CITY OF ALBUQUERQUE

RE: **Durango at the Trails (File: C09D012)**
Drainage Report for Units 1 to 4
Engineer's Stamp Date 10-24-2014

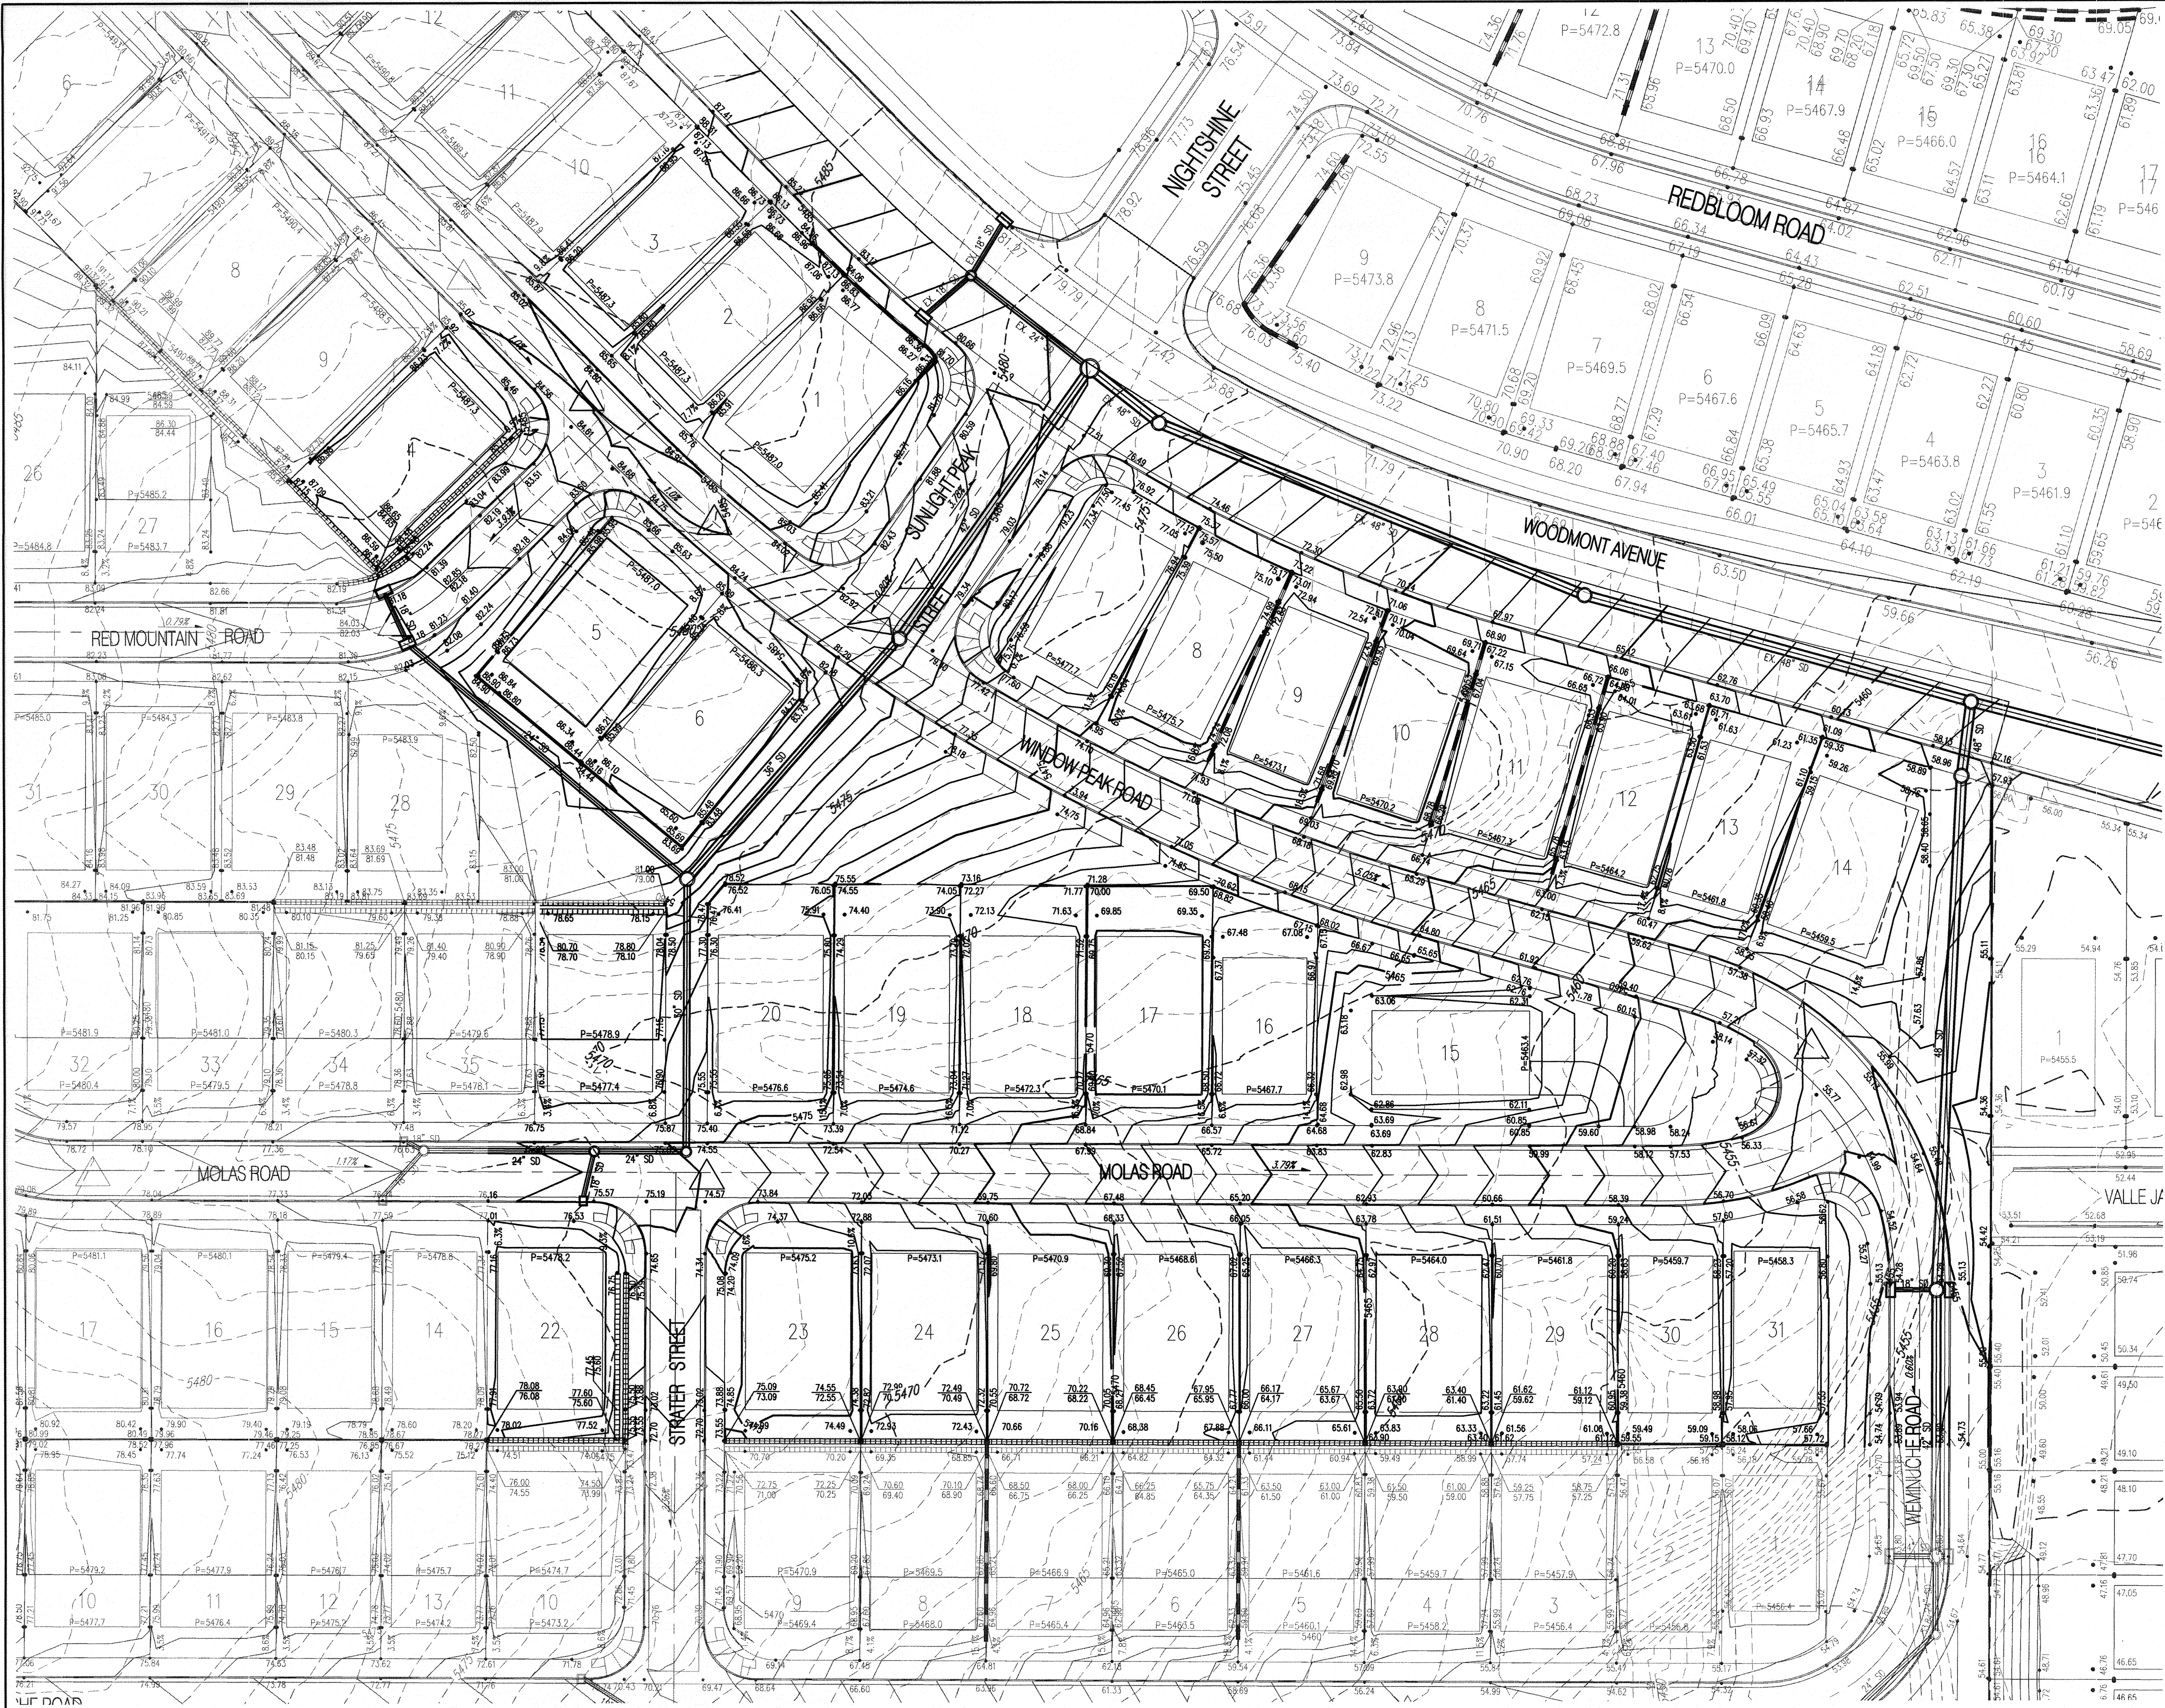
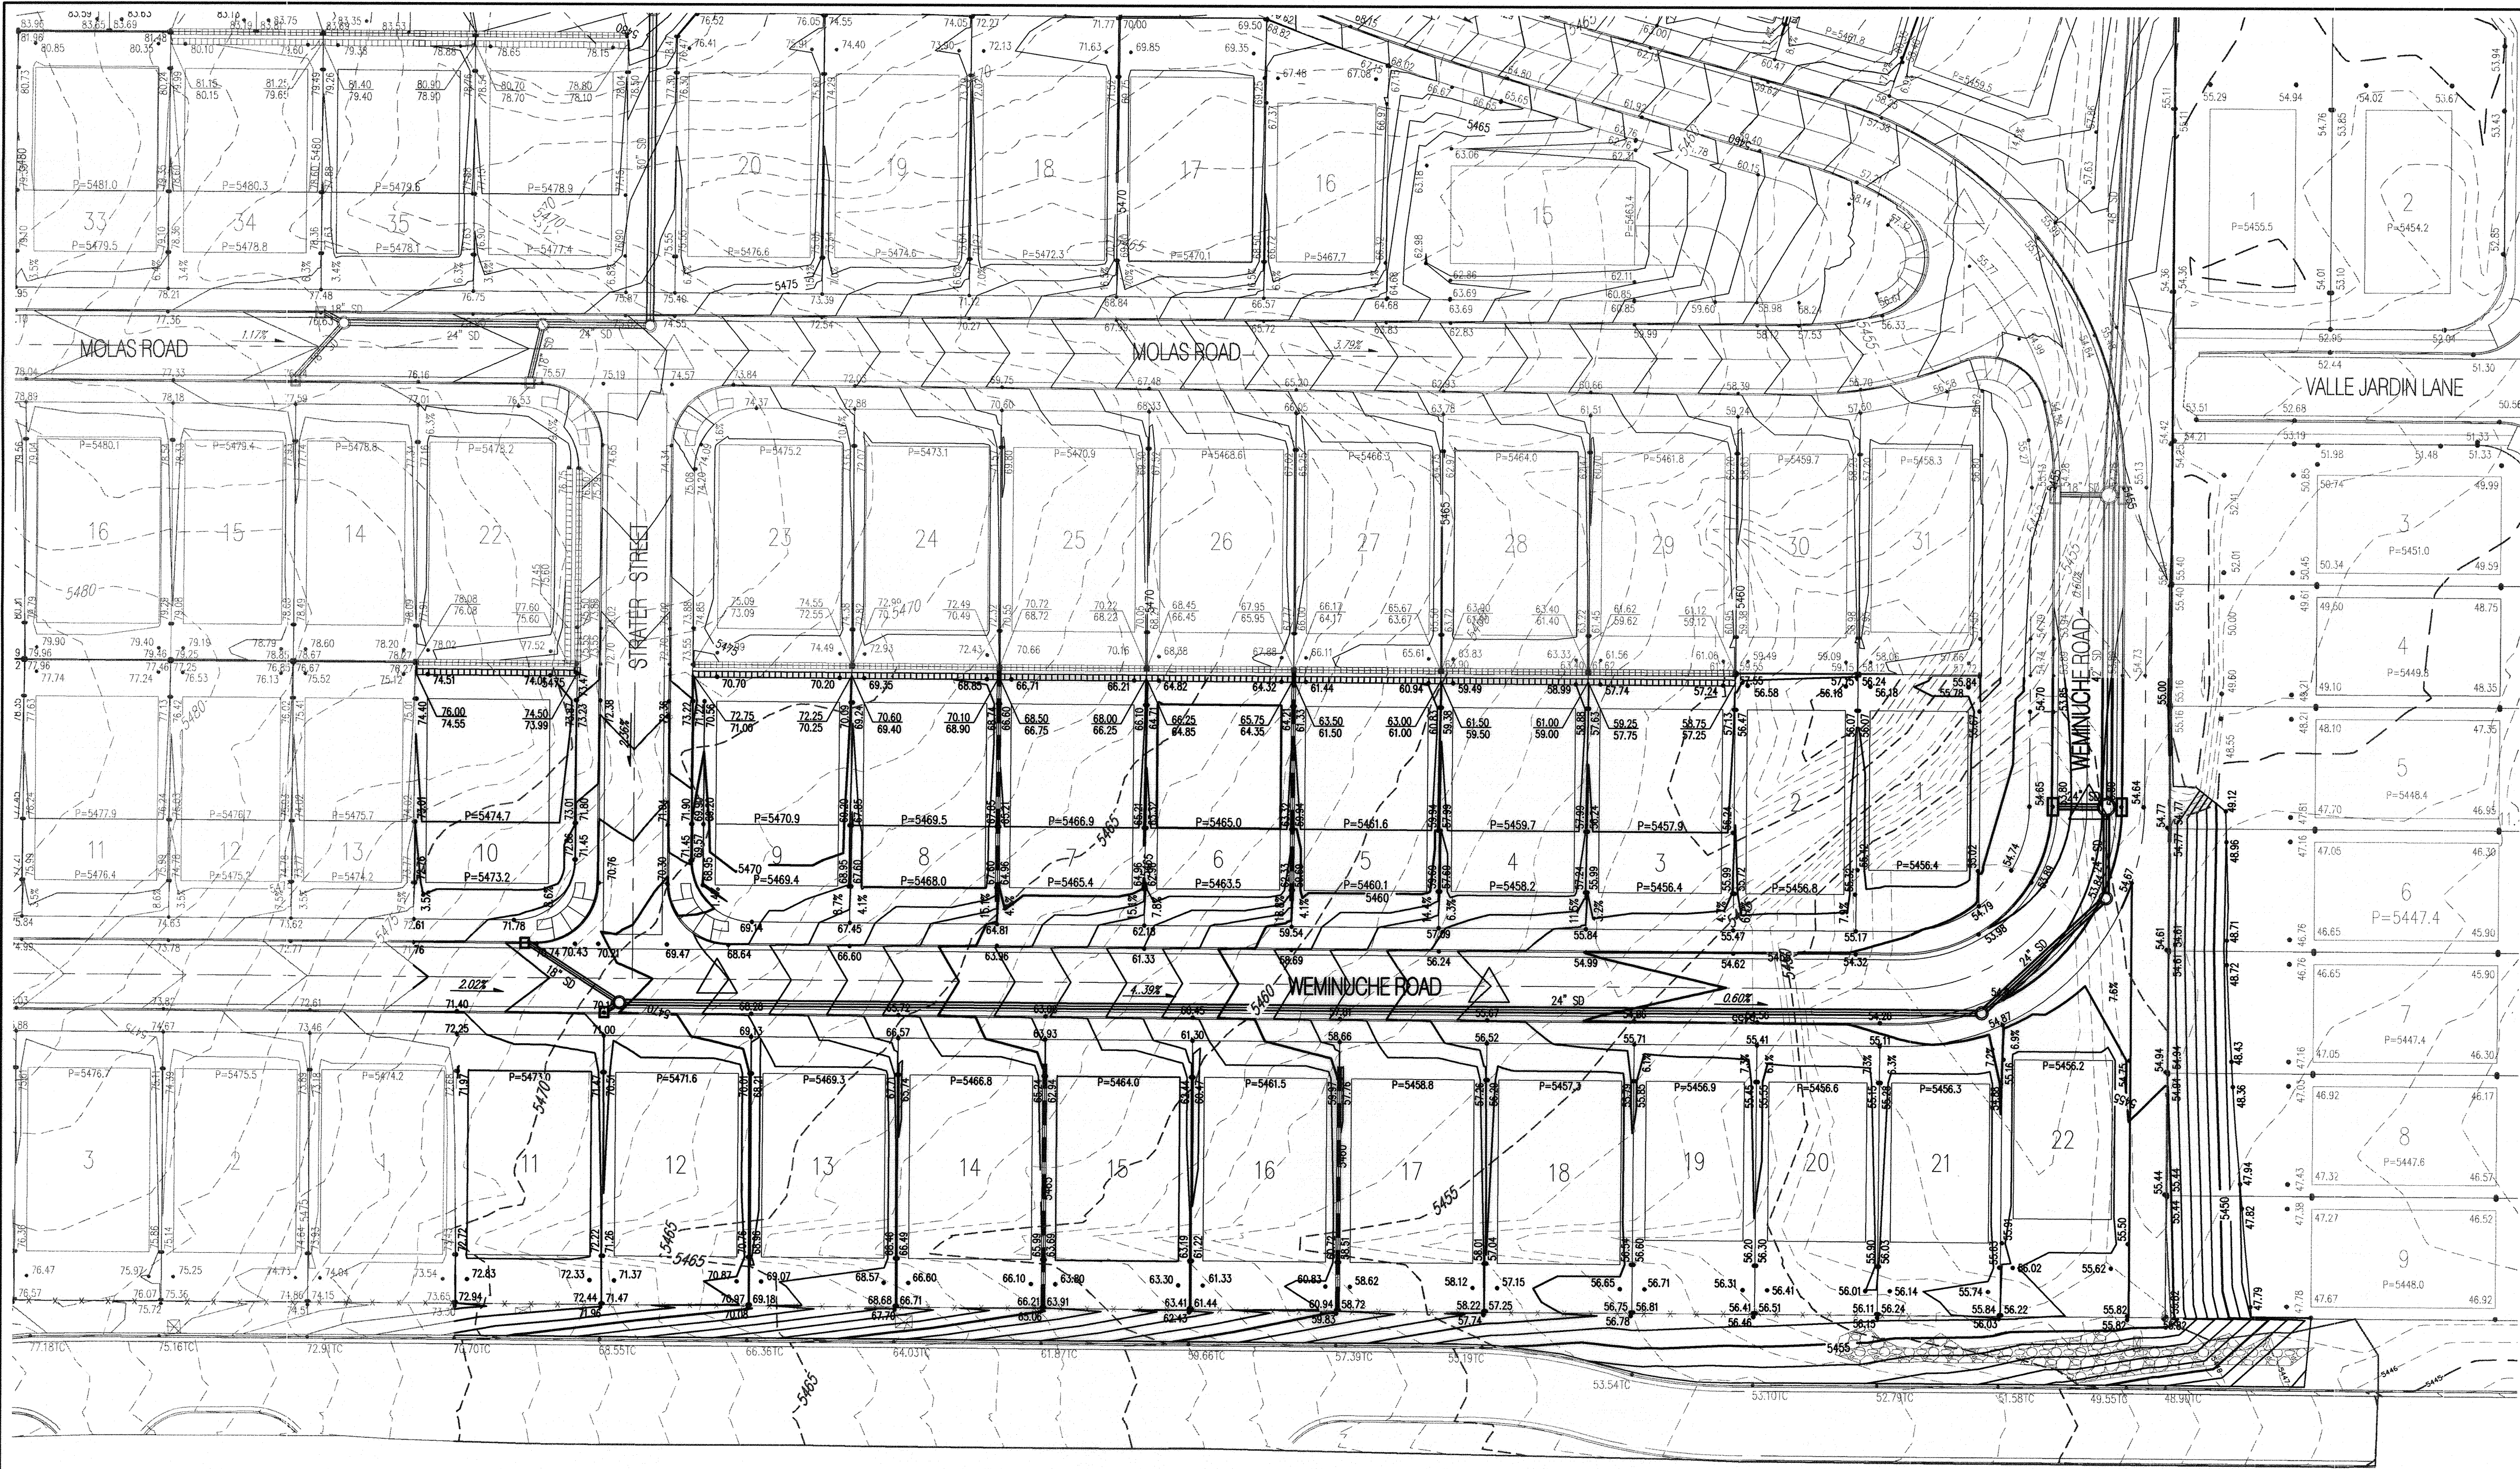
1. Units 1 thru 4 are to be phased. Provide an interim grading plan for each phase, showing sediment ponds and tie slopes.
2. Provide revised grading plan showing recent changes. Grades and retaining walls will be checked after this plan is submitted.
3. Revise I.L list with for separate line items for each run/size of pipe.
